MEMORANDUM

TO: Jean Fraser, Planner
FROM: David Senus, P.E. & Ashley Auger, E.I.T.
DATE: May 15, 2014
RE: 421 Warren Avenue, Final Level III Site Plan Application

Woodard & Curran has reviewed the Final Level III Site Plan Application for the proposed 6-unit commercial complex located at 421 Warren Avenue in Portland, Maine. The project consists of constructing a single-level 25,000 SF industrial building along with associated site improvements, which will result in approximately 56,252 SF of new impervious area. The project is being reviewed for compliance with City of Portland Level III Site Plan requirements and under the City's delegated review authority for Chapter 500, Stormwater Management Law.

PROJECT PH WARREN AVENUE, LLC
SHEET TITLE SITE LAYOUT AND UTILITY PLAN

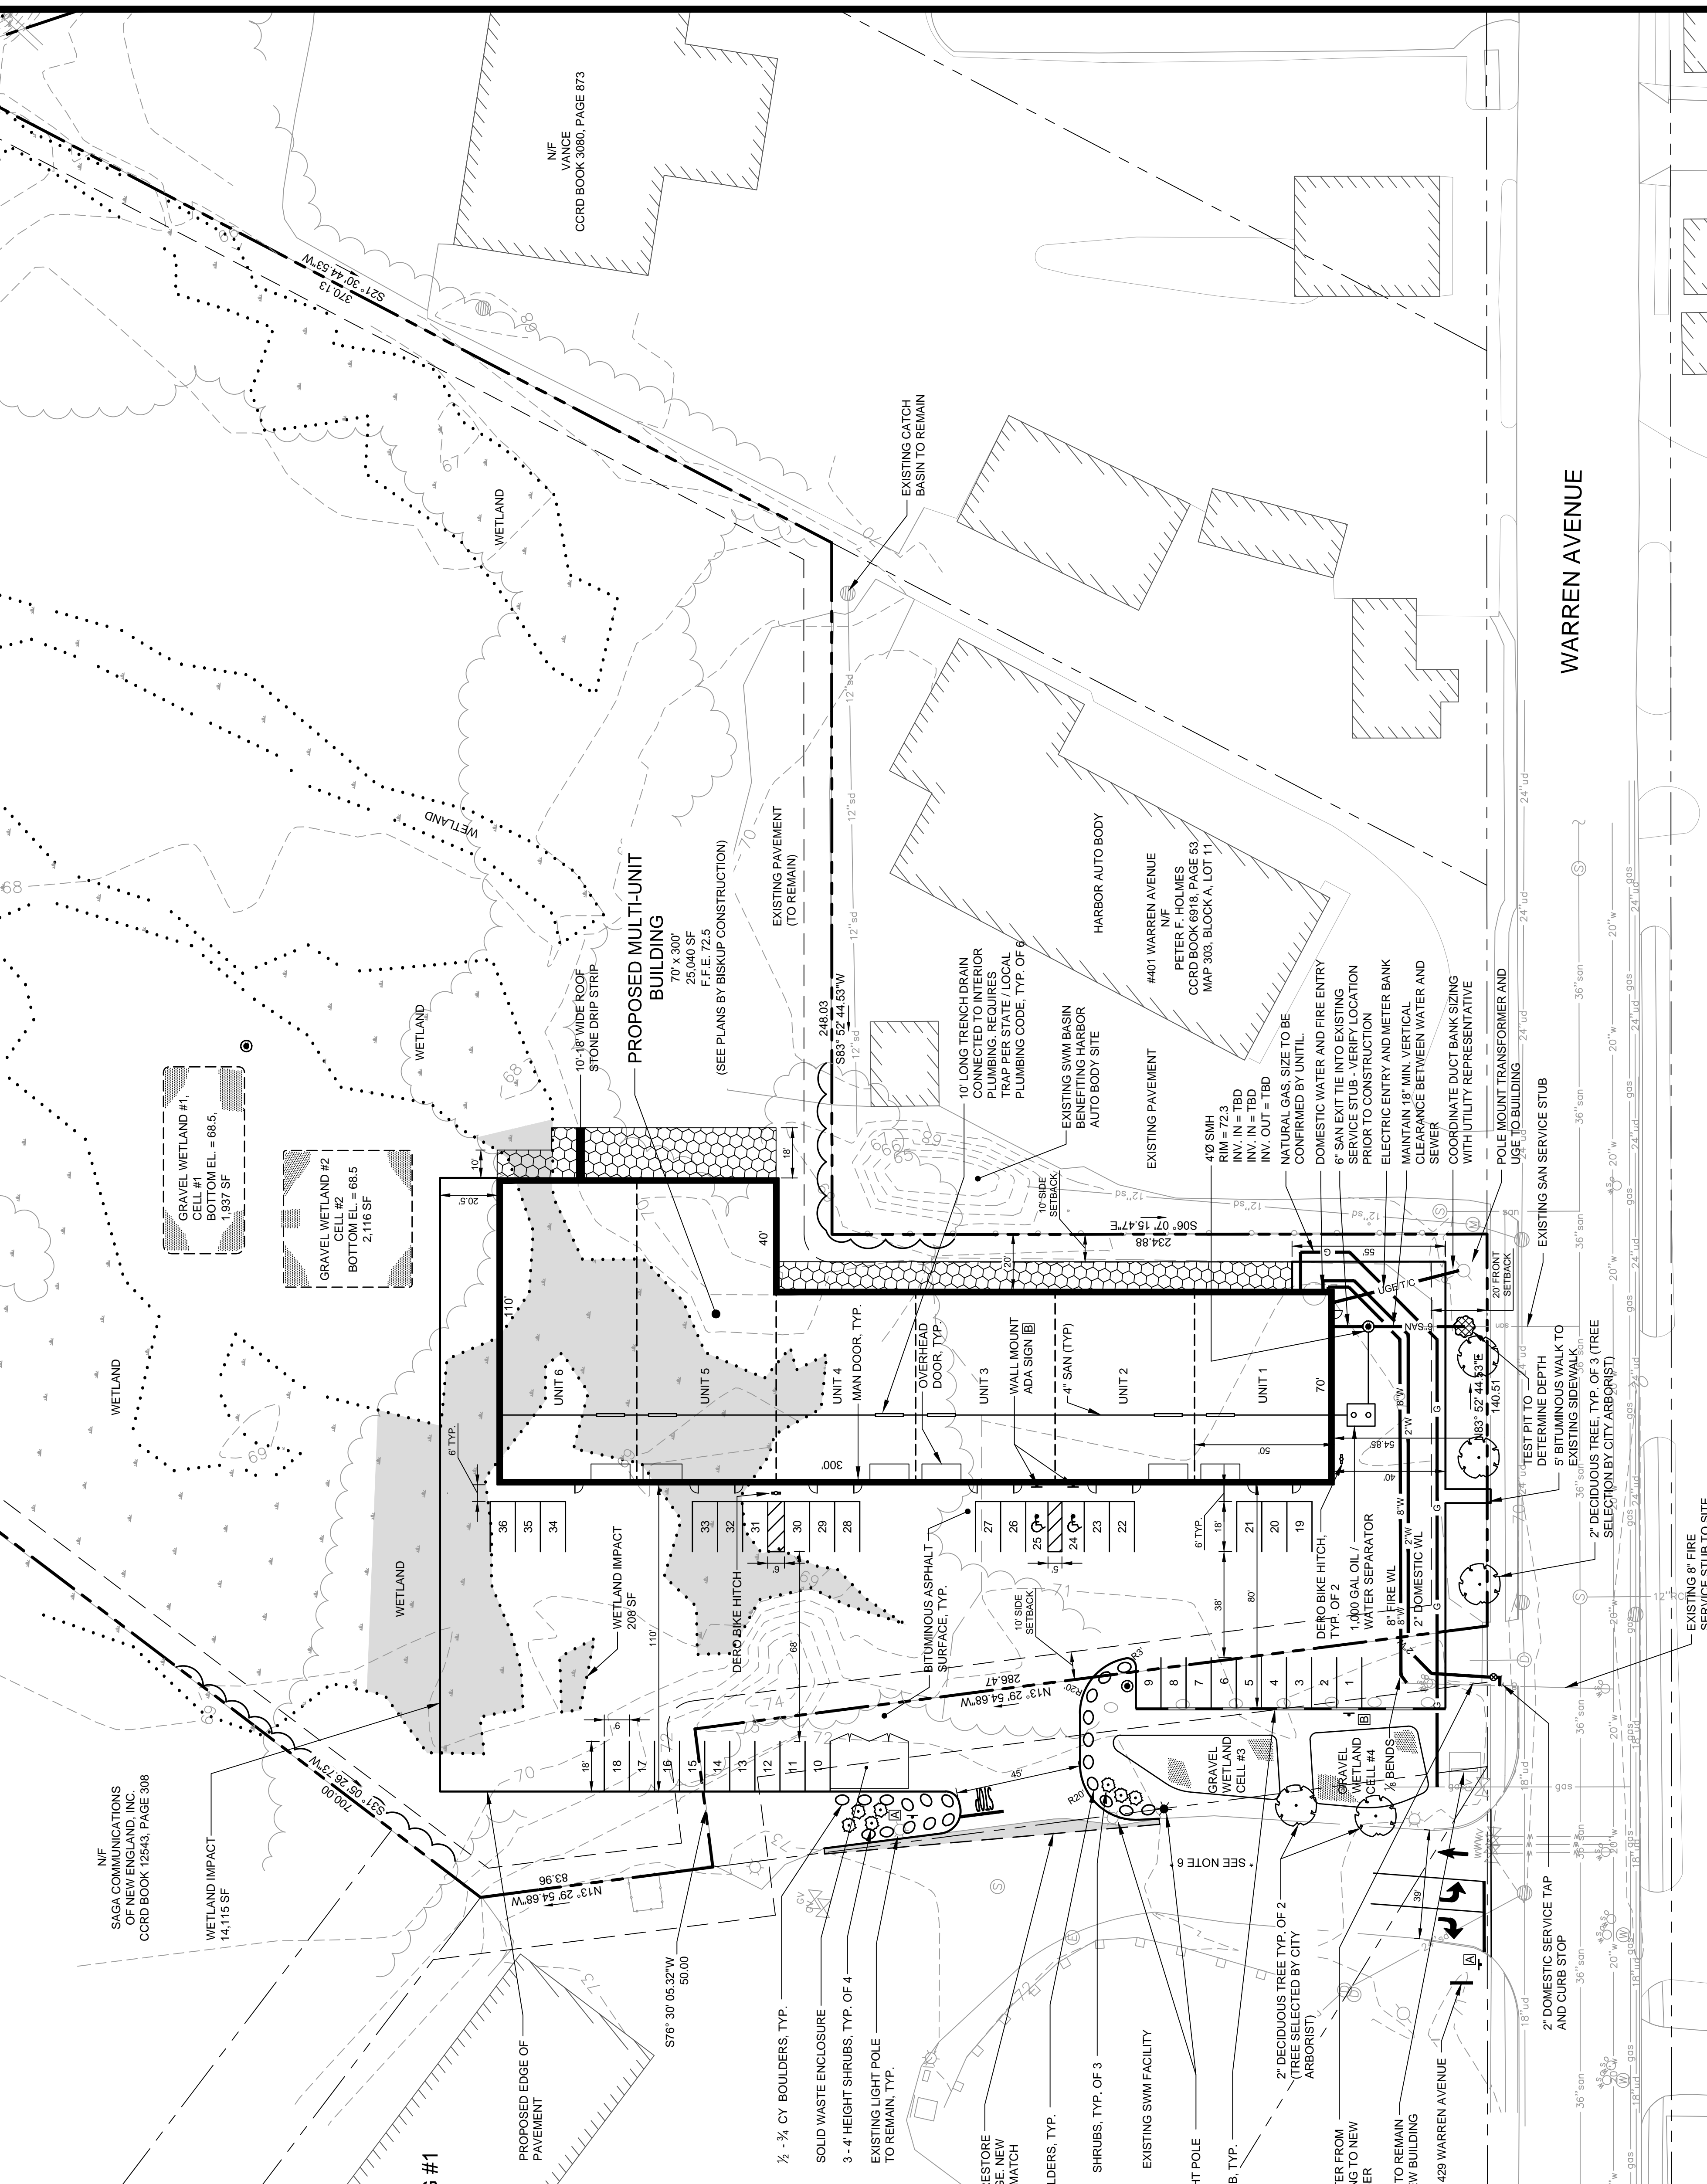
2. It would be desirable for the applicant to tap for the 2" domestic water service behind the sidewalk to avoid cutting into the sidewalk.
3. Please note on survey plan that Saville Street and Newcomb Street are Continued Paper Streets as per City Council Order #84 in September 1997.

4. Please add State Plane Coordinates for four (4) corners; at both ends of the rear 657.94' line and at both ends of the 140.51' line along Warren Ave.
